“AMENDMENT” OF THE PRELIMINARY DRAINAGE REPORT

Claremont Business Park 2 Filing No.1

A RESUBDIVISION OF TRACT C OF CLAREMONT BUSINESS PARK FILING NO. 2

Project #44-037
PCD – SP 197

PROPOSED DRAINAGE MAP

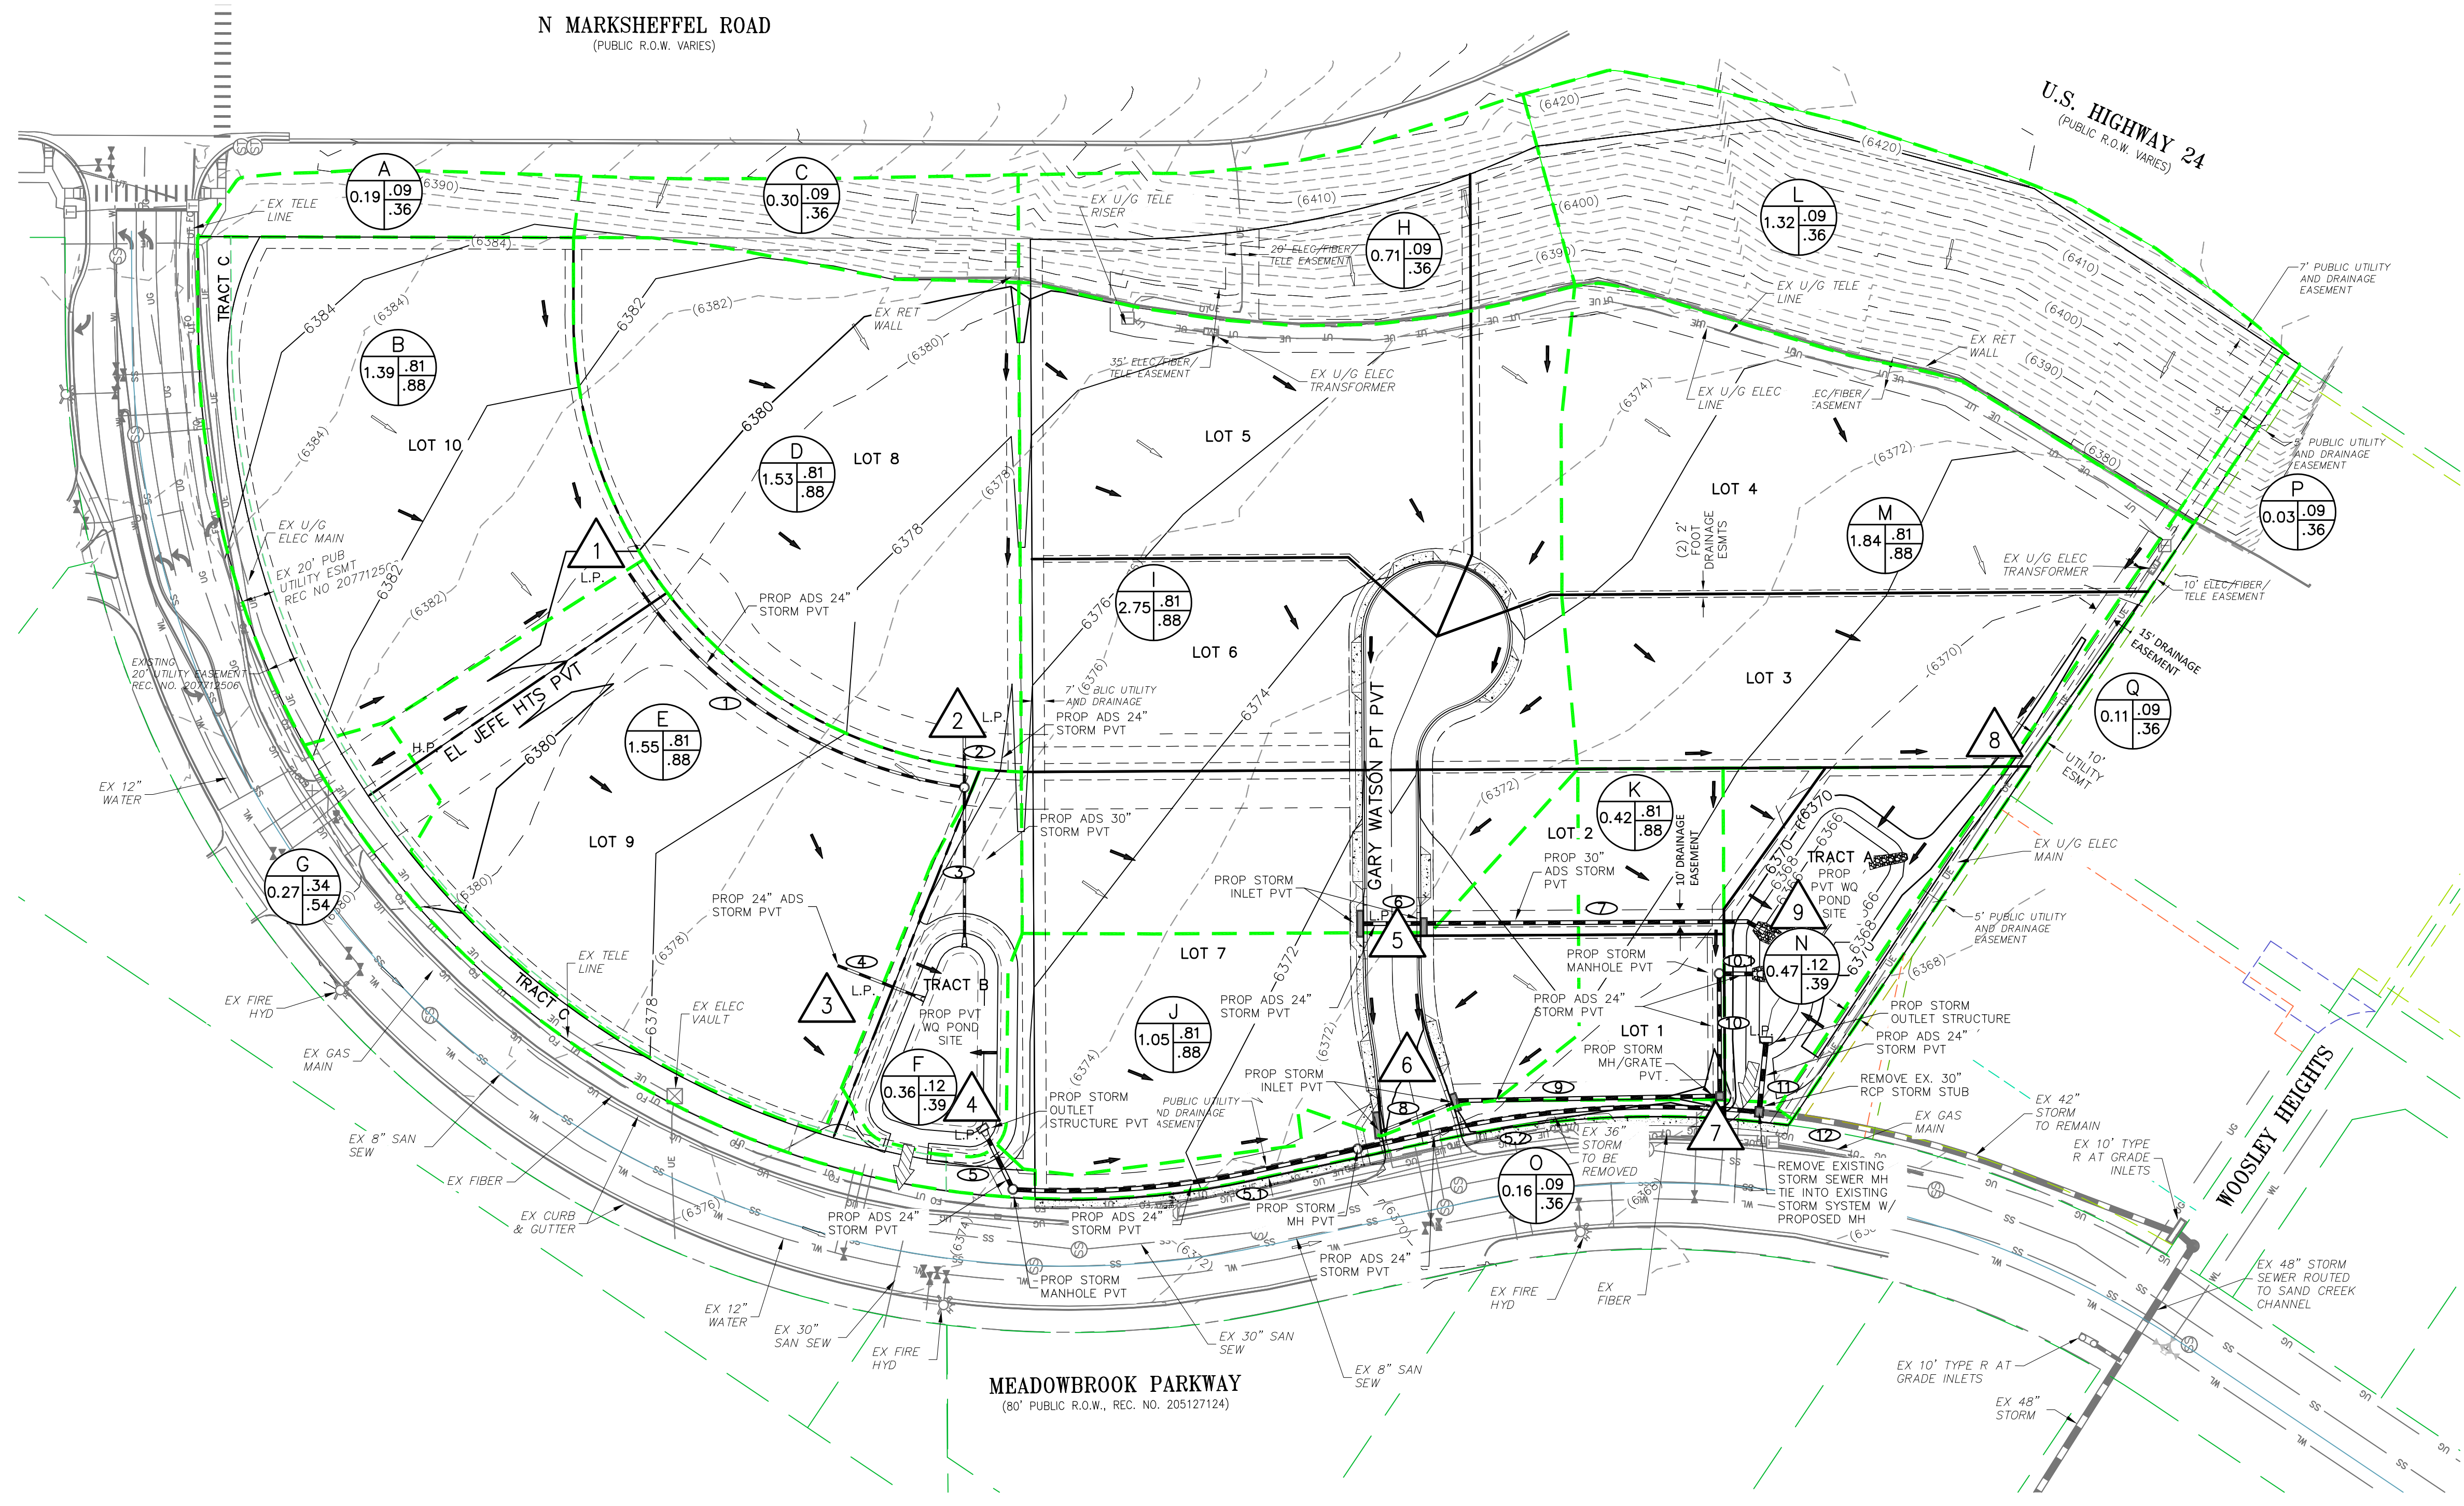
The callout for the 36" pipe is located in basin O. revise accordingly.

It appears that the existing 30" stub may conflict with your proposed 30" ADS pipe. Please clarify.
